From: [REDACTED]
To: [West Burton Solar Project](#)
Cc: [REDACTED]
Subject: FW: EN010132 – West Burton Solar Farm
Date: 09 January 2024 19:22:00

With respect to the Examining Authority's written questions and requests for information, Nottinghamshire County Council has the following responses to make. For speed, these comments are made in the form of an email rather than a formal letter.

Application by West Burton Solar Limited for an Order Granting Development Consent for the West Burton Solar Project

**WEST BURTON SOLAR PROJECT**

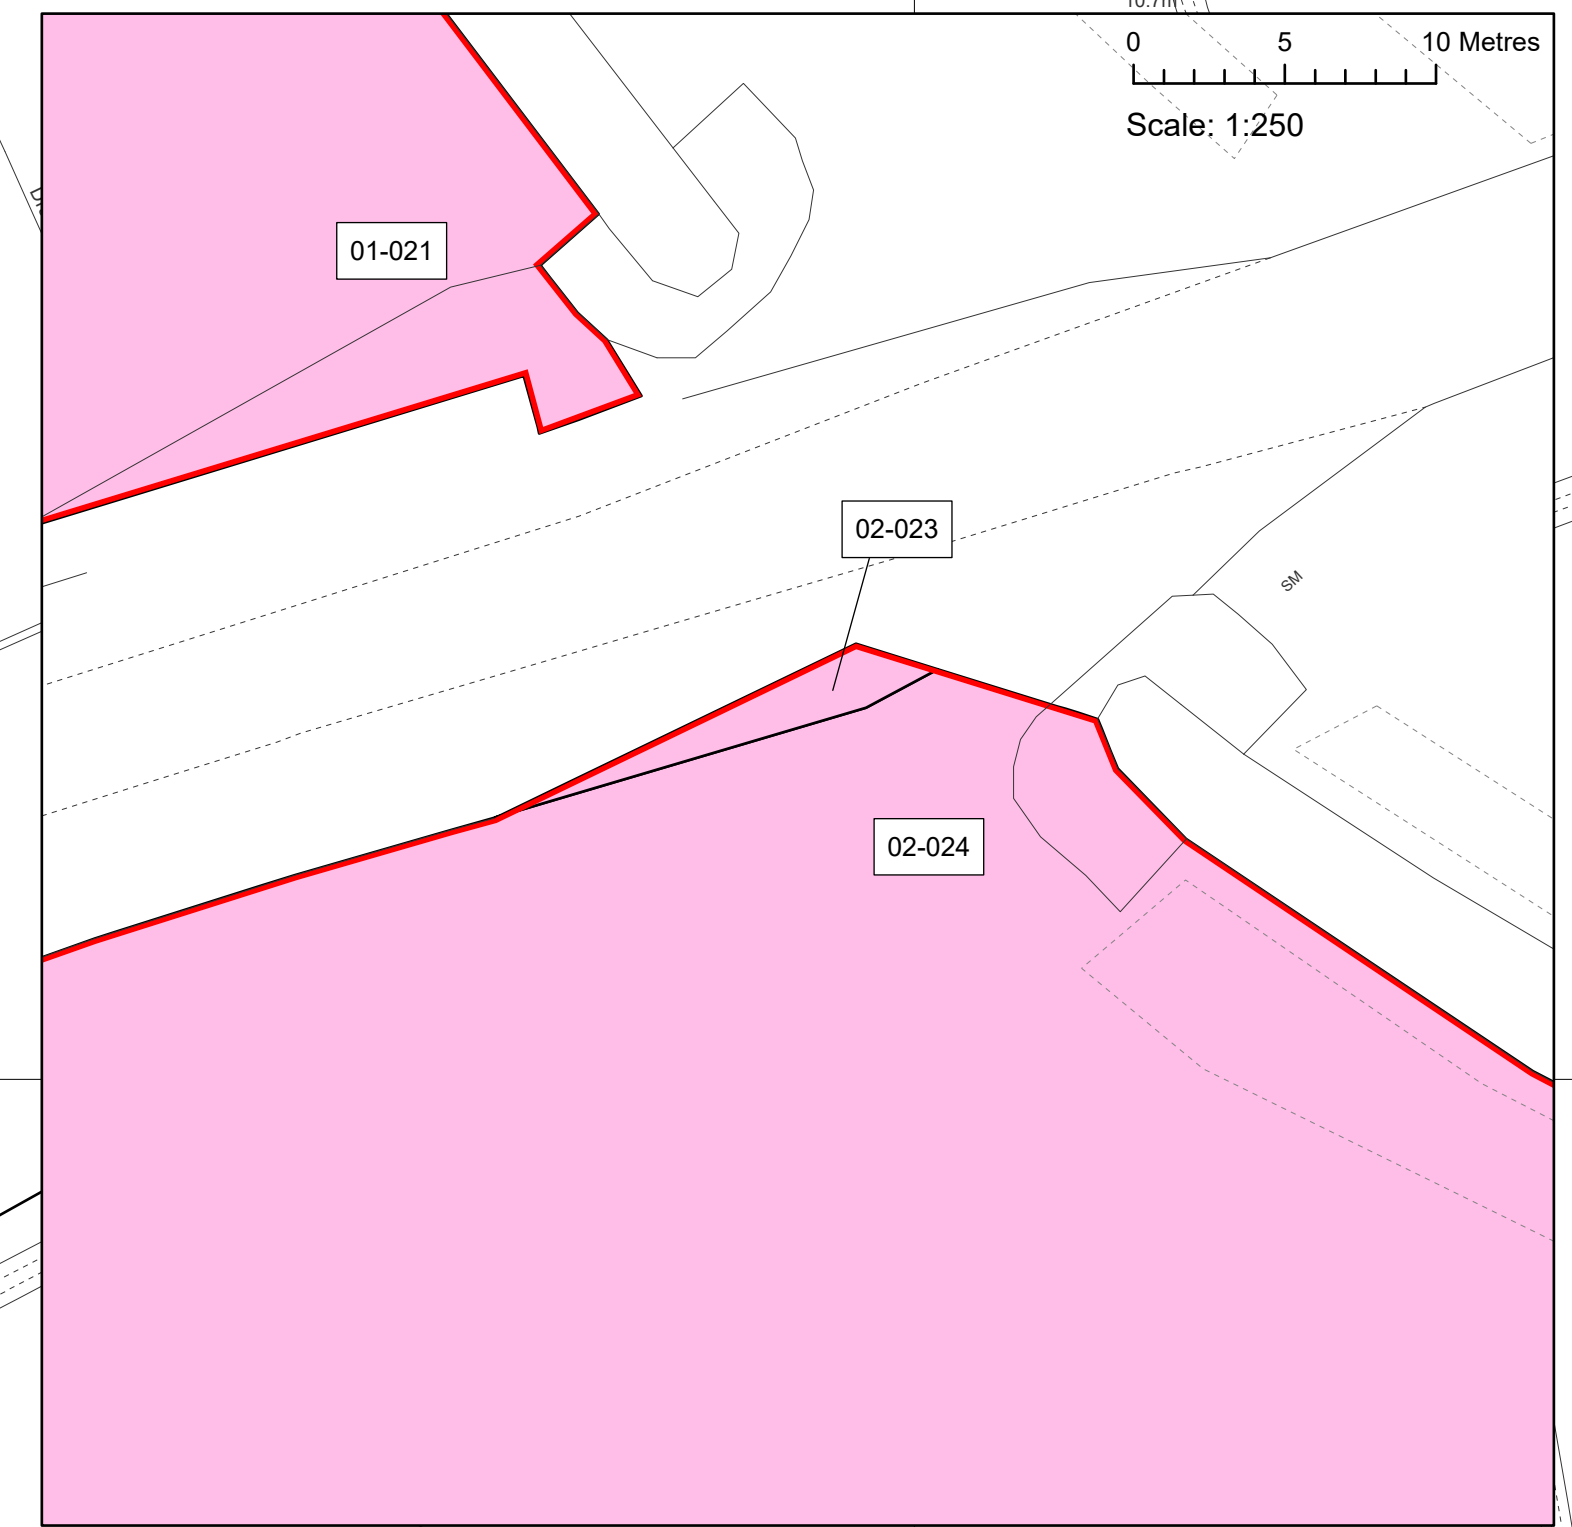
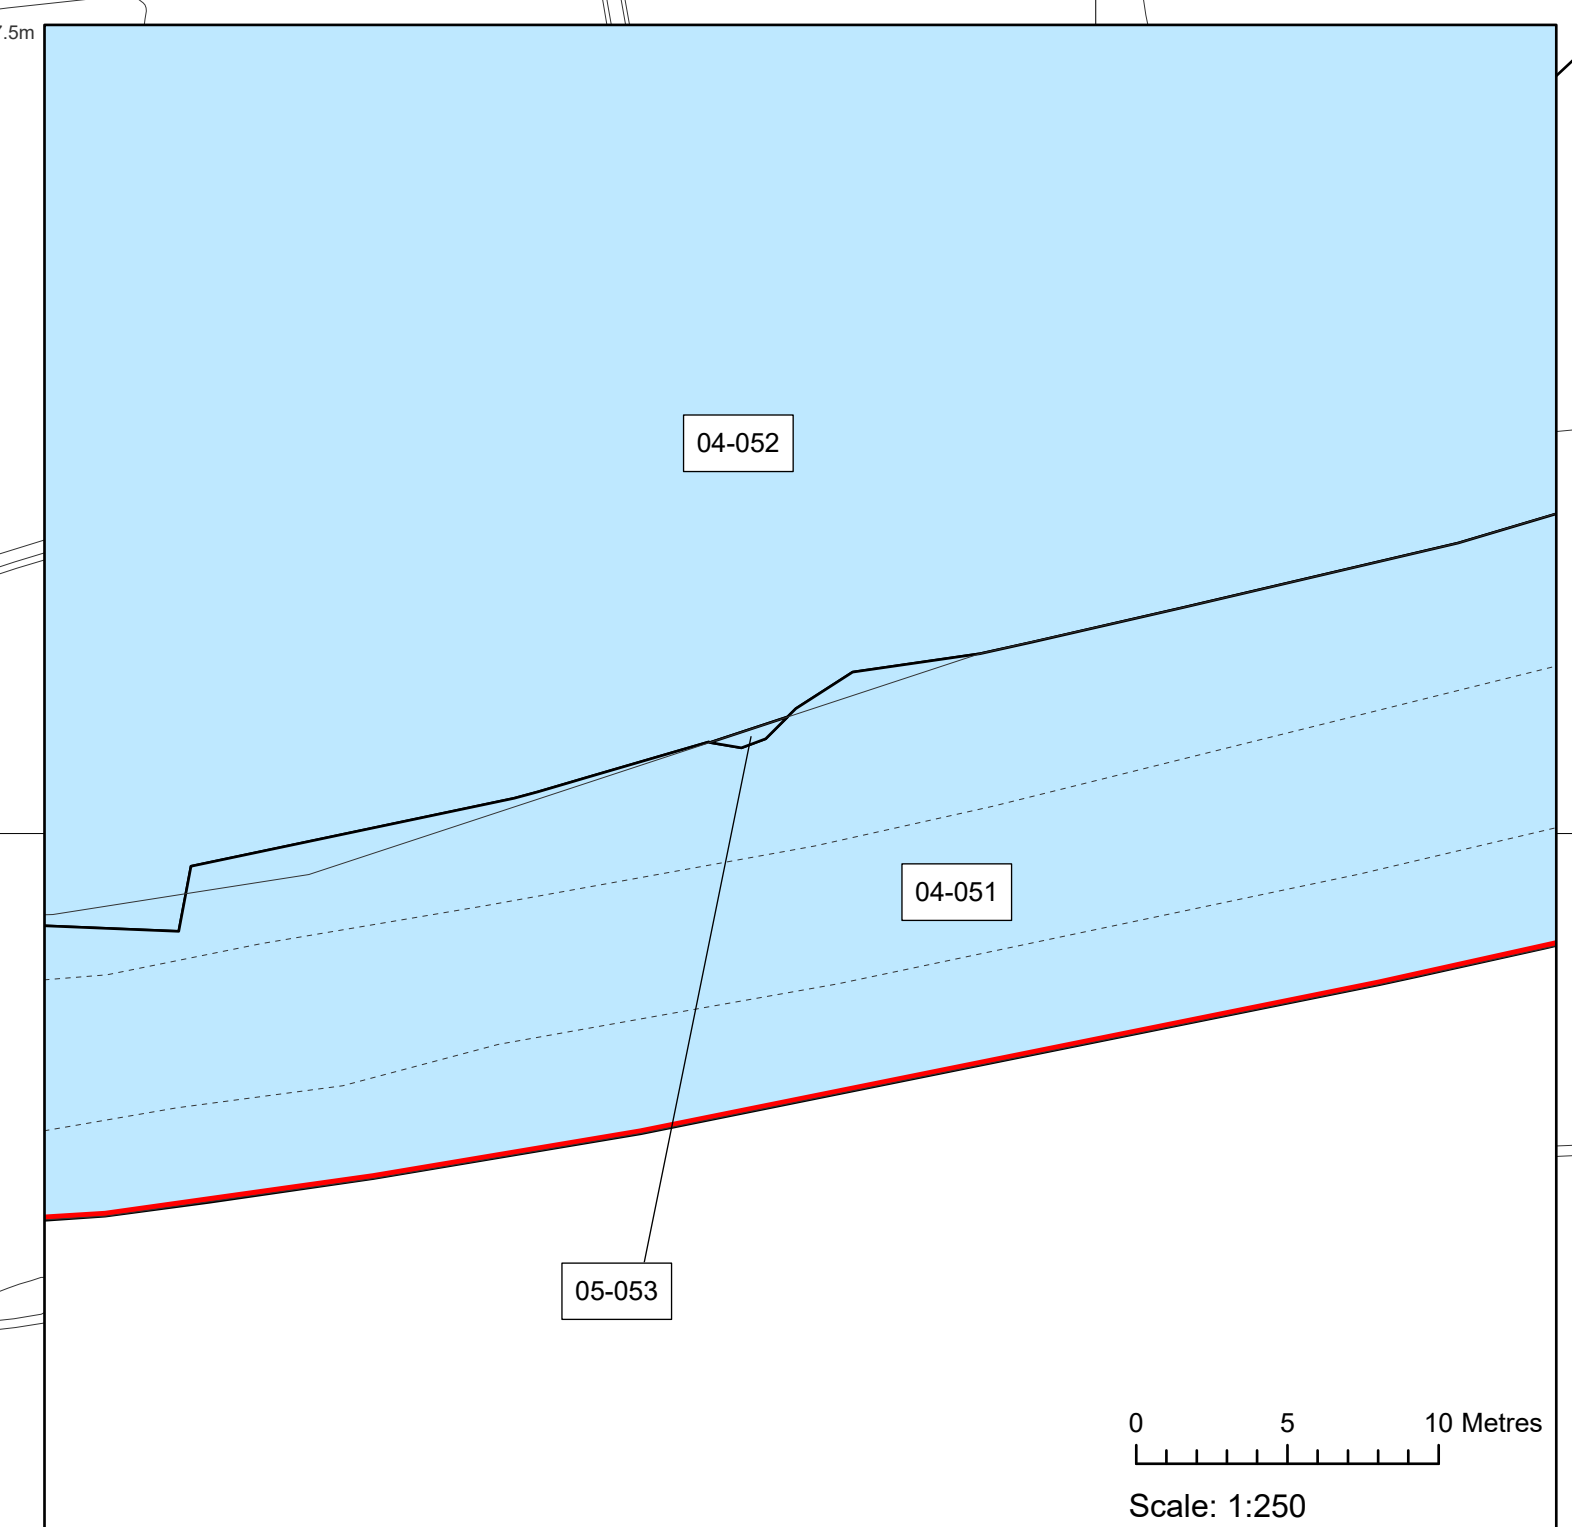
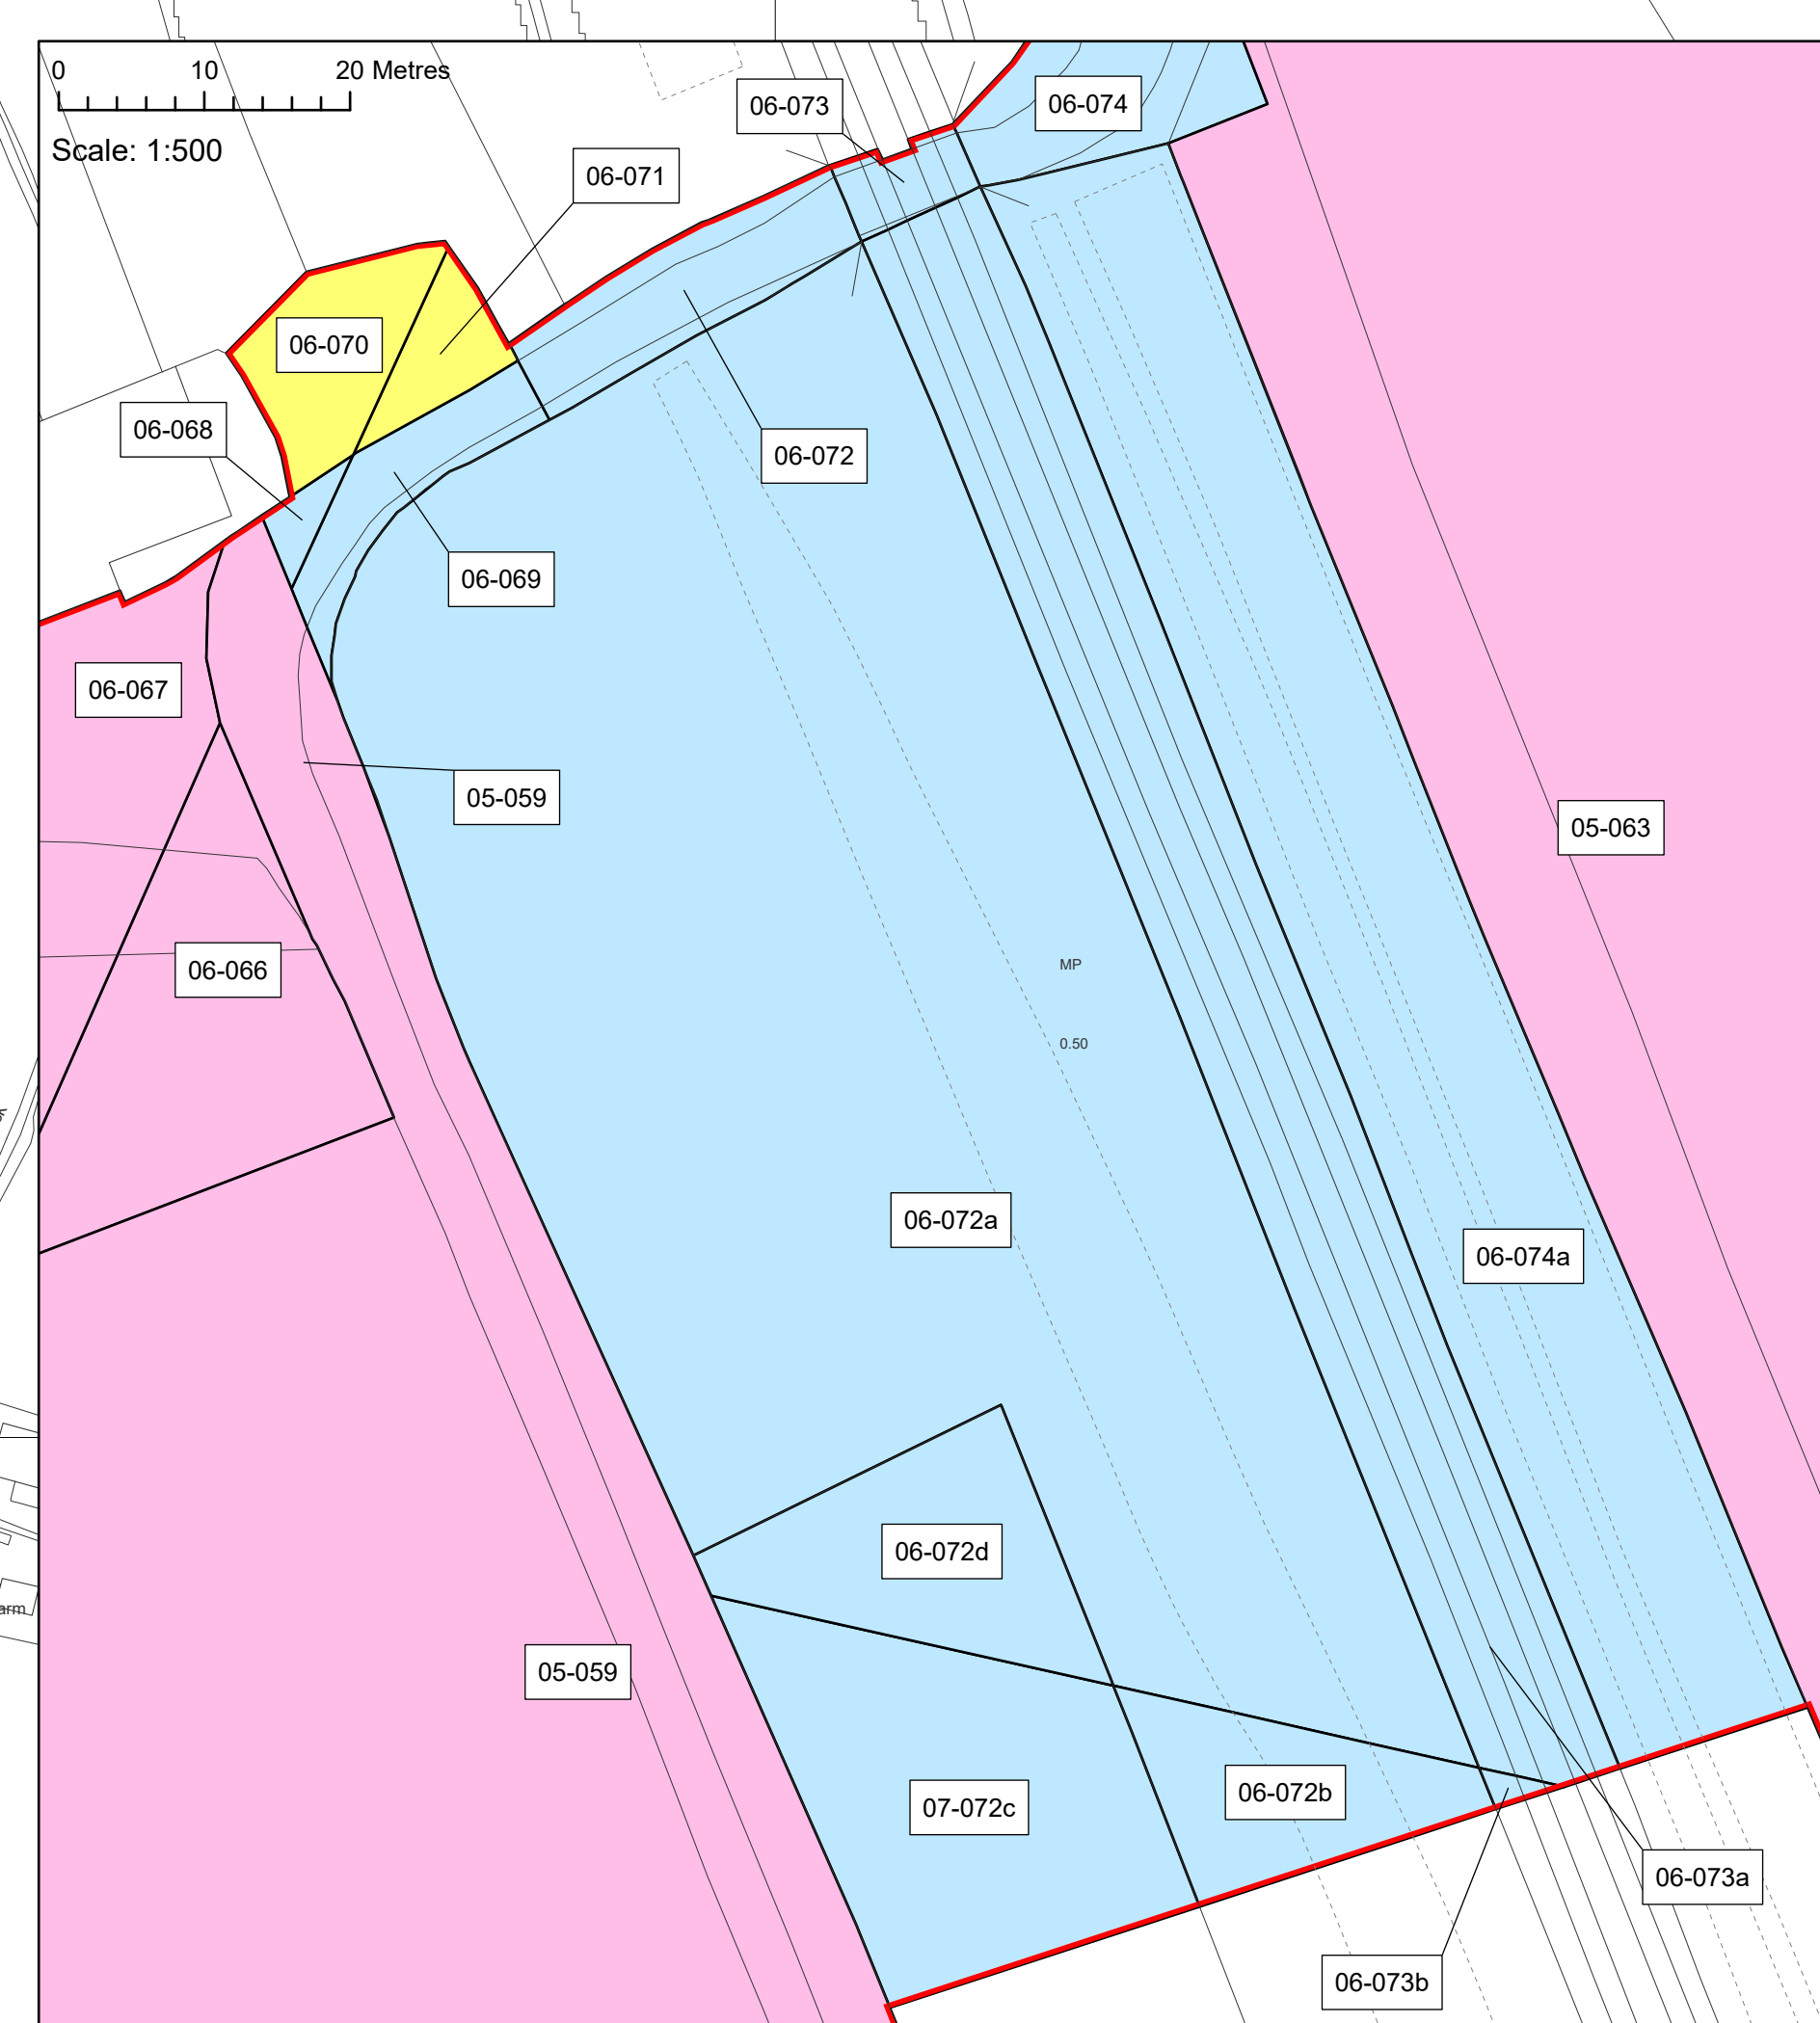
In terms of compulsory acquisition (shaded blue on the Land Plan), this primarily relates to land associated with the cable corridor. Whilst this route does cross the public highway it will have no effect on its legal status as Highway. All public highway is subject to the legal maxim, 'once a highway always a highway' which applies regardless of any change in ownership, unless a separate stopping up order is granted by the Secretary of State for Transport. Regardless of ownership the provisions of the Highways Act 1980, Traffic Management Act 2004, and associated legislation such as the New Roads and Street Works Act 2004, will still apply. Any works contained within the Highway would be subject to legal provisions, agreements and licences required under the associated legislation.

These provisions regulate construction works within the highway as well as other associated activities such as the laying of services and cables etc. Consequently, it is unclear why any change of ownership or compulsory acquisition of land within the Highway Boundary would be required.

The same applies to land for which temporary possession is being sought (shaded yellow on the land plan). Any temporary works within the Highway required for access etc, would be covered by the relevant legislation. There may be an argument that temporary possession of land outside of the Highway may be required to facilitate access for larger vehicles and abnormal loads. However, having reviewed the Abnormal Load strategy contained within Appendix F of the Transport Assessment, for the access points located in within Nottinghamshire (access points AC103 – AC108), it would appear only access point AC108 is likely to require third party land, presumably to allow vehicles to turn around at the end of the route.

There are a number of smaller areas of land shown as temporary possession direct adjacent to access points located at AC103, AC104, and AC107. These do not appear to be required for access purposes, it is presumed given their proximity to the Highway that they are being acquired by the developer on a temporary basis for use as site compounds / staging areas. We are unable to comment as to whether or not these areas are excessive as the area required will be subject to operation requirements determined by the developer.
